Date: 13 July 2015

Proposed Application by Keuper Gas Storage Limited for an Order Granting Development Consent for the Keuper Gas Storage Project

The Planning Inspectorate's comments on the Applicant's pre-application core draft documents

**HOLFORD BRINEFIELD - KGSP - ABOVE GROUND
WORKS PLAN [REGULATION 5(2)(I)] - SHEET 9 OF 9**

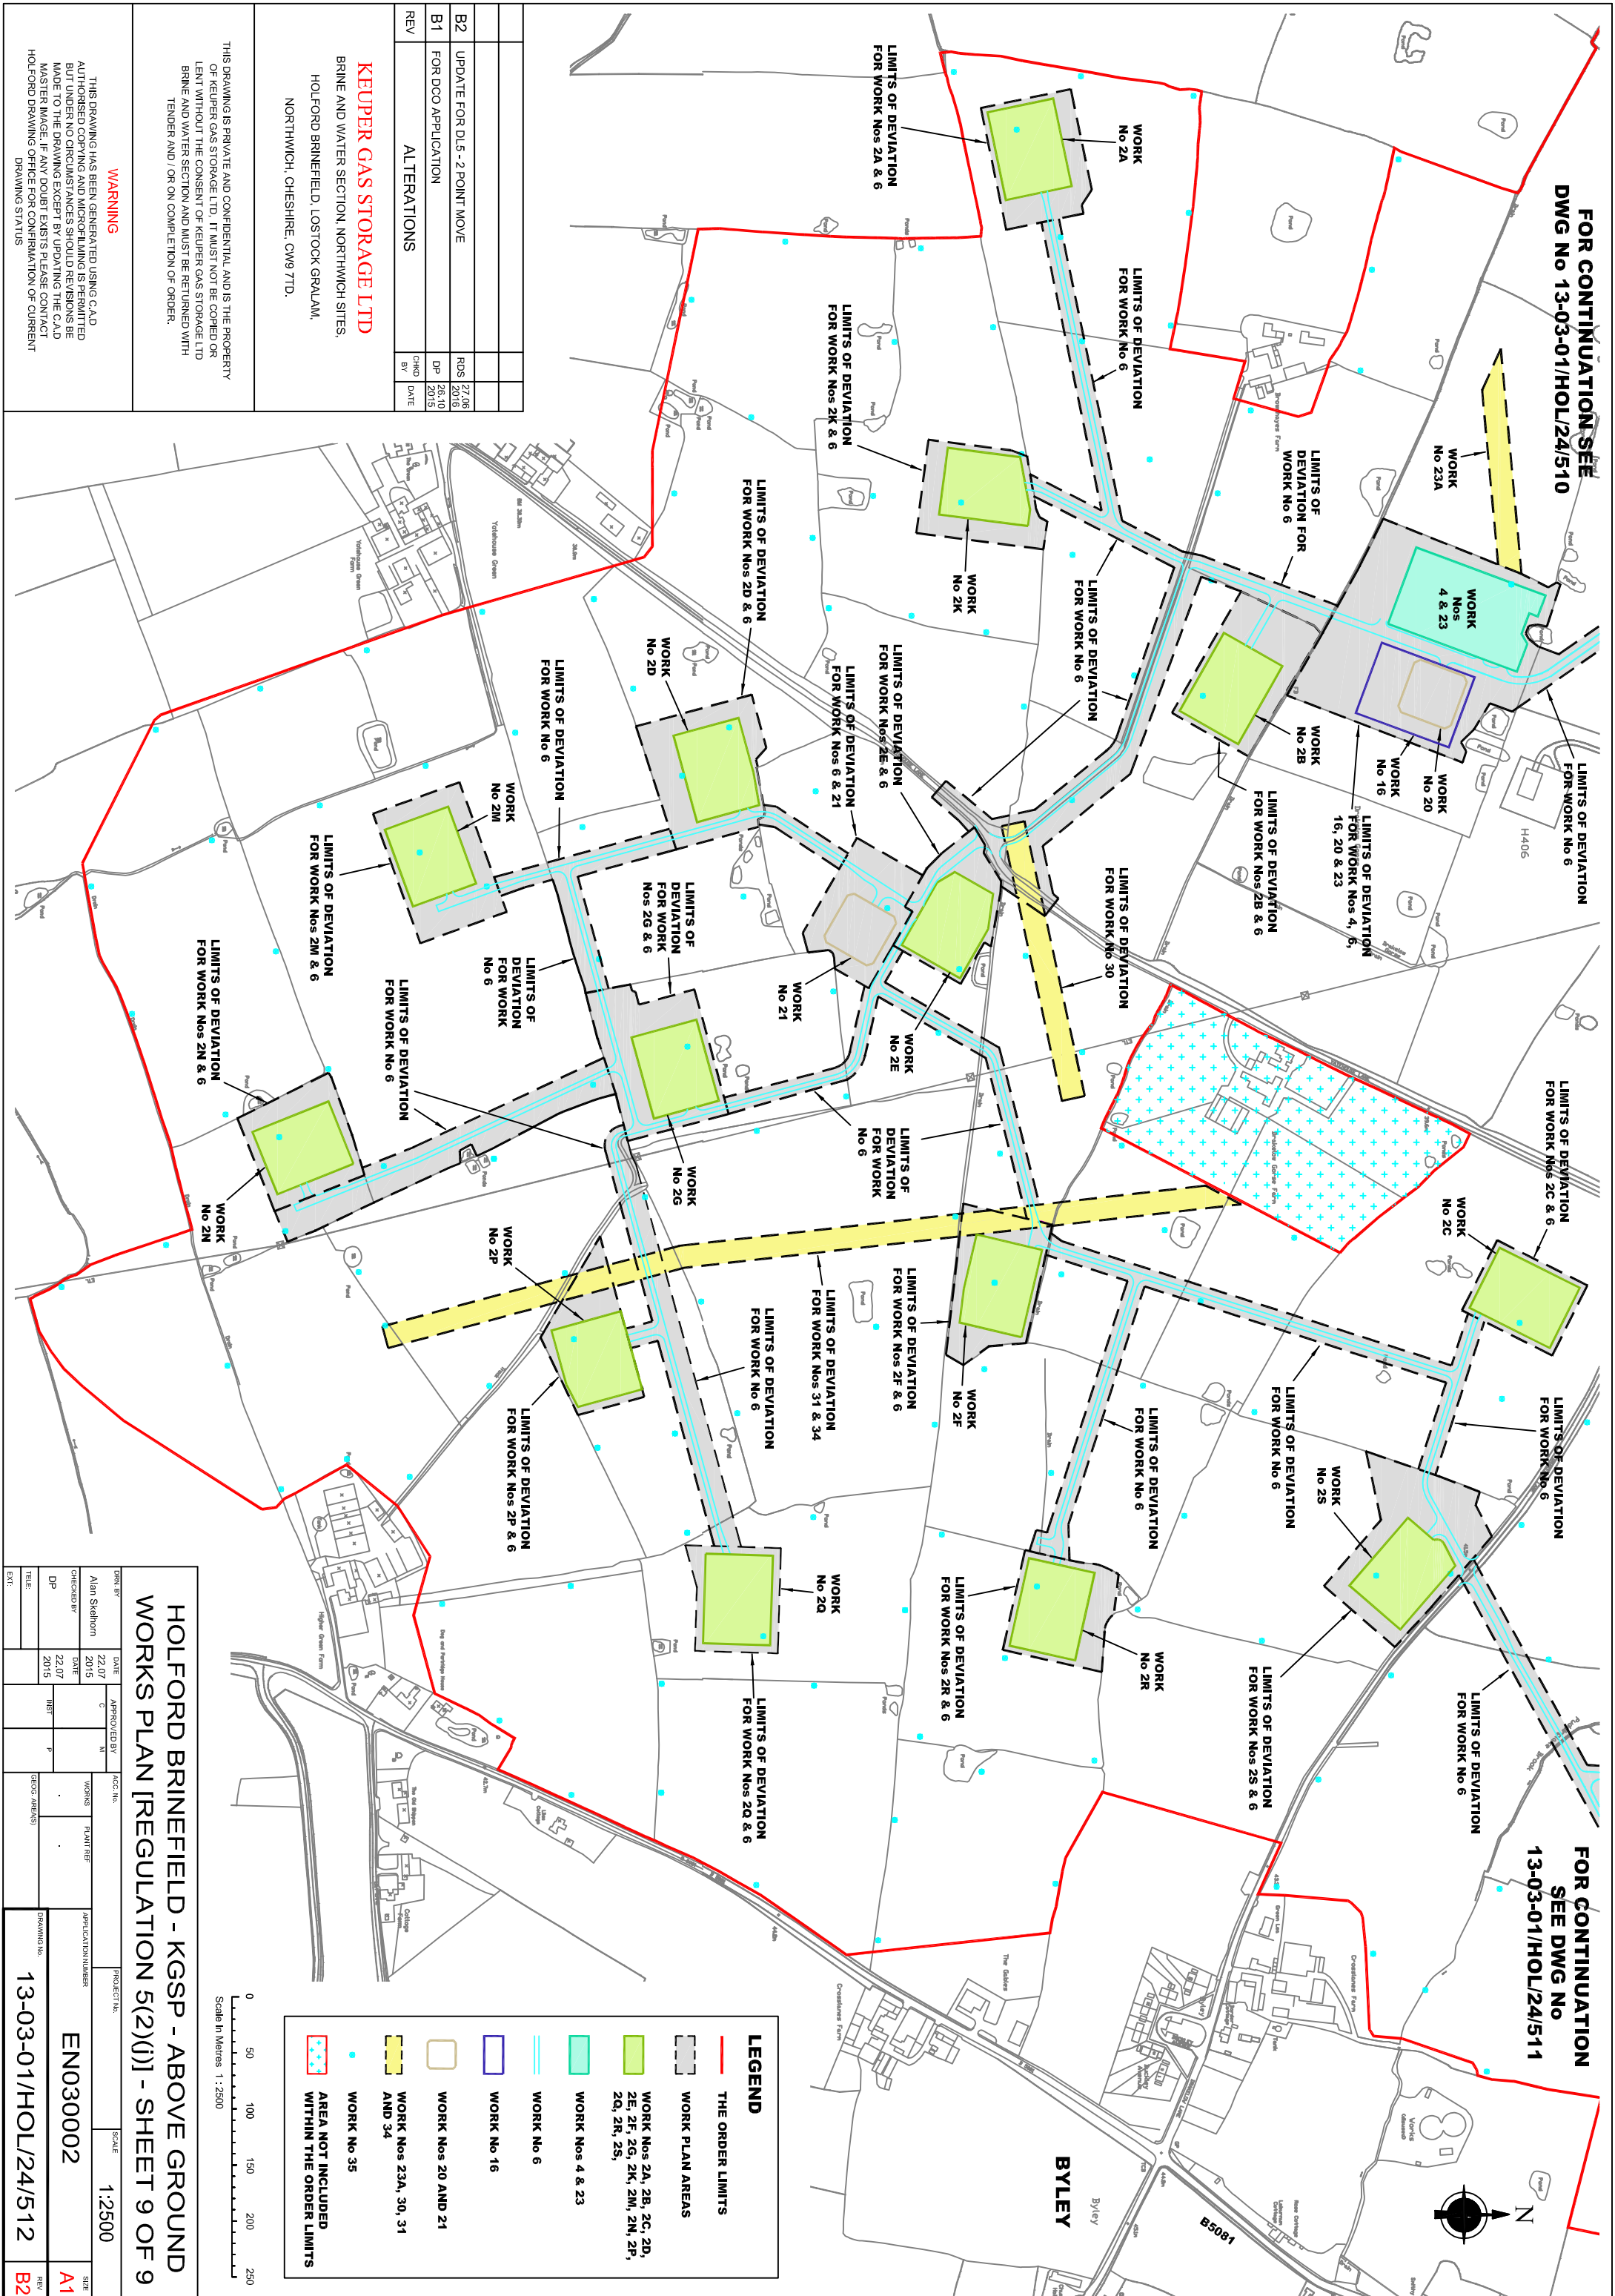
Similarly work No 6 for 'access road network' appears that it will, in part, be over land which the applicant has rights but has not compulsorily acquired the freehold.

- We suggest the use of colour and/or shading to better depict the works.
- We suggest fewer Works per plan to aid clarity.
- Greater detail is needed as currently the Works are blocked together in areas. This approach doesn't sufficiently show each work. The approach used in the general arrangement plans (231 – 233) is more useful.
- Work No 5 doesn't appear to be on works or general arrangement plans.
- Work No 8 – why is this work not contained within the individual works for each cavity (Works 1A – 1U).
